Planning application WA/68/26/PL — Land North of The Green Way, West Walberton Lane, Walberton
Supplementary representation: the Planning, Design & Access Statement and the title documents it does not mention

Appendix A — Application red line (1804/DP01 Rev 01) overlaid on the applicant’s topographical survey (25371)

Location Plan

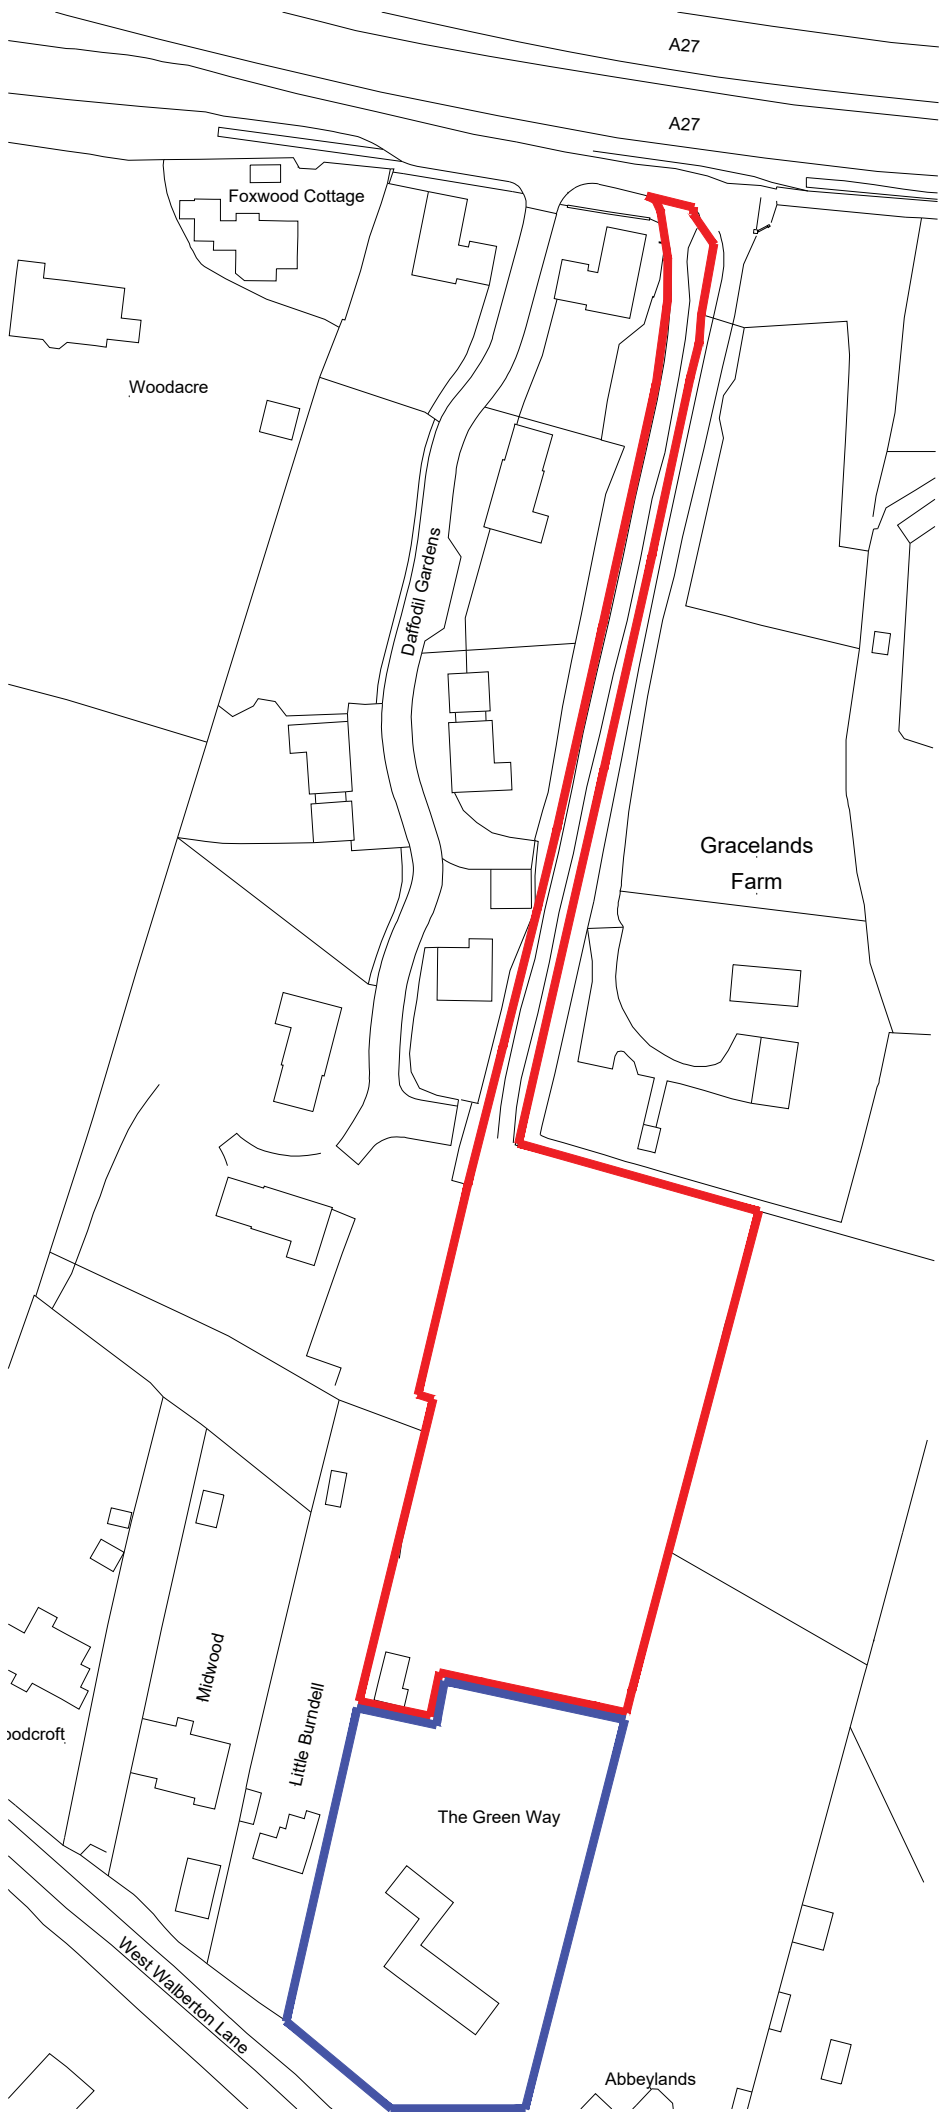
The application is accompanied by Certificate A, certifying that the applicant is the sole owner of all land within the red line. The red line on Location Plan 1804/DP01 Rev 01 includes the full length of the access corridor from Arundel Road. For the reasons above, persons other than the applicant hold interests in land within that boundary. I raised this in my letter of 21 August and respectfully ask that the certificate be reviewed before the application proceeds to determination; if Certificate A was given in error, the notice requirements attaching to Certificate B have not been met and the consultation is defective in that respect.

The PDAS treats the red line and the boundaries on the ground as one and the same. The applicant’s own topographical survey — drawing 25371 by J. Brotherton & Partners, dated 5 September 2025 and submitted with this application — shows otherwise. I have taken the red line from the vector geometry of drawing 1804/DP01 Rev 01, calibrated against its own scale bar, and placed it on the survey’s Ordnance Survey grid by least-squares fit of the drawing’s OS base mapping to 695 surveyed fence points (RMS residual 1.26 m). The comparison is enclosed as Appendix A. In summary:

- along the access corridor, the red line coincides with the surveyed eastern fence but runs 2.0 to 4.5 metres inside the surveyed western fence for the corridor’s full length — the fenced corridor is 7 to 9.6 metres wide where the red line claims 5.4 to 6.1 metres;
- at the southern end, some 831 square metres of the application parcel lie beyond any fence recorded by the applicant’s surveyor, extending up to 24 metres past the surveyed southern boundary — land within the red line that the submitted survey never covered.

- The red line's east edge follows the surveyed east fence of the drive; its west edge runs 2.0-4.5 m inside the west fence for the corridor's full surveyed length.
- Adding the fenced western strip (≈350 m² surveyed, more beyond) to the red line would take the site over the 0.5 ha ceiling for the self-build BNG exemption claimed at DAS \$5.16.
- 831 m² of the red-line parcel lies south of any surveyed fence, extending up to 24 m beyond the surveyed southern boundary; that land was not covered by the survey.
- The FRA's 0.556 ha site area matches neither the red line (0.495 ha) nor the fenced ground, and remains unexplained by any measured combination.

Drawing Title Topographic Land Survey

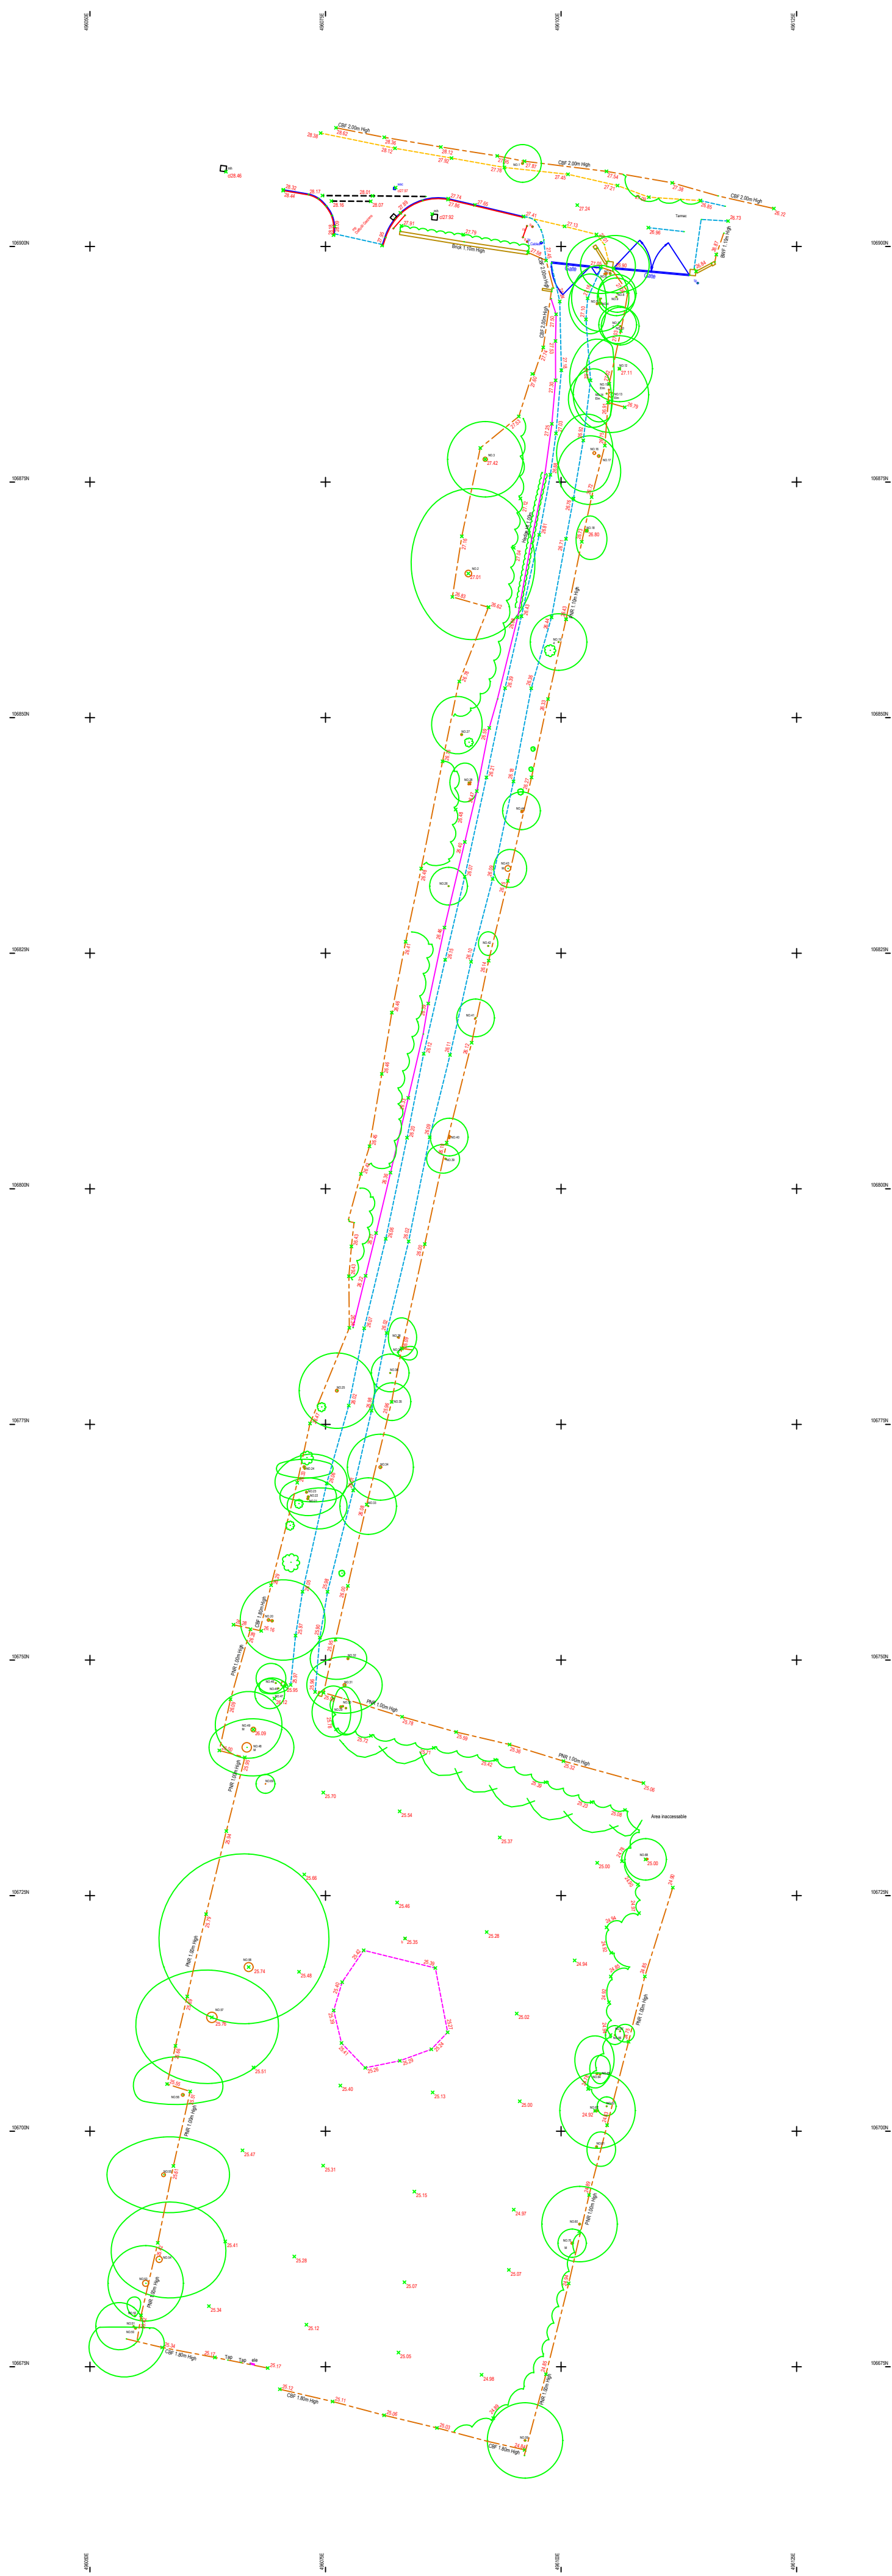
western corridor and the southern parcel (Appendix A)
5.16	Self-build exemption from 10% Biodiversity Net Gain	Exemption requires a site of 0.5 ha or less; the red line measures 4,947–4,961 m ² , i.e. 40–50 m ² below the ceiling, and excludes fenced parts of the corridor that would take it above
